## Subdivision Comments

To: Bradley Gasawski, CDS Planner I

From: Dan Suggs, Environmental Health Specialist II

RE: SP-24-00011 Lewis

LEWIS SHORT PLAT

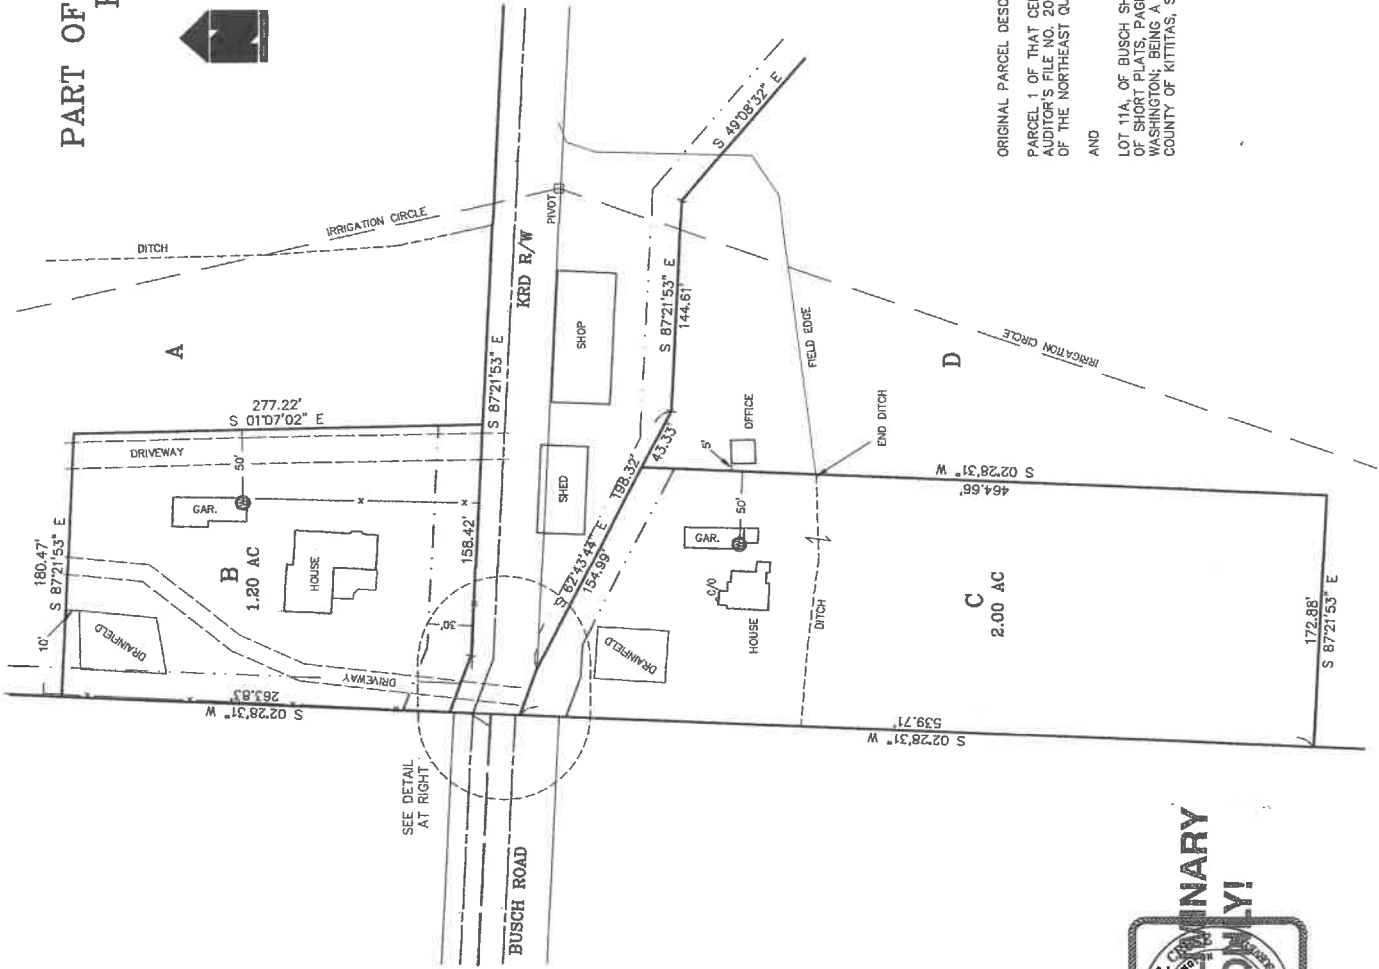
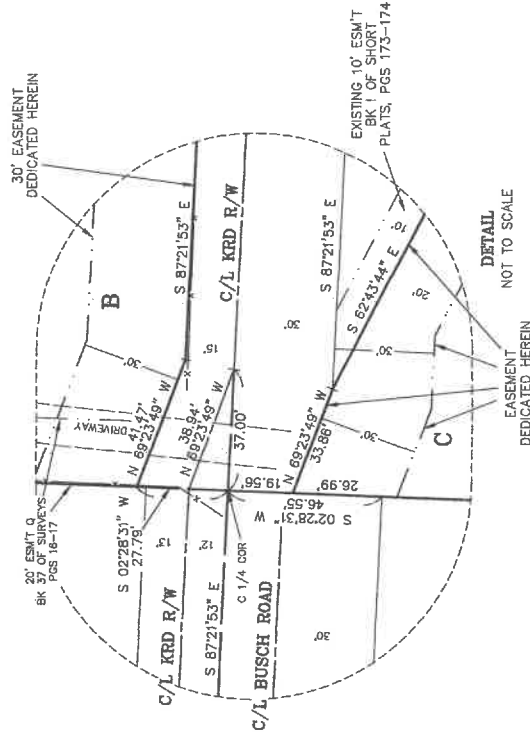
Lot B & Lot C have existing on-site septic systems. Proposed lot B & C will meet the minimum land area requirement for on-site sewage systems and individual wells. Proposed lot A & D are proposing on-site septic systems.

Lot B & C have existing individual wells currently serving individual residences. Proposed lot A & B will share the individual well located on 821 Busch Road (lot B). Proposed lot C & D will share the individual well located on 822 Busch Rd. (lot C).

- Soil logs are required to be recorded for lot A & D. Soil logs may be conducted by a professional engineer, licensed wastewater treatment system designer or KCPHD.
- The existing wells on lot B & C must be fifty feet from all roads and property lines. If the lot lines are not configured to allow a one-hundred-foot radius protection zone to fit within the lot lines, then a one-hundred-foot protection zone must be recorded on the plat.
- Adequate water supply determination is required for the proposed land use. The adequate water supply determination must include:
  - Valid shared well users agreement signed by both users of the well that is recorded

- Passing water quality tests for coliform (within 1 year) and nitrates (3 years).
- A well log recorded within the last ten years or if a well log is not available a 4 hour draw down test. If the water source production is less than five gallons per minute, a water distribution system design must be submitted by a professional engineer.
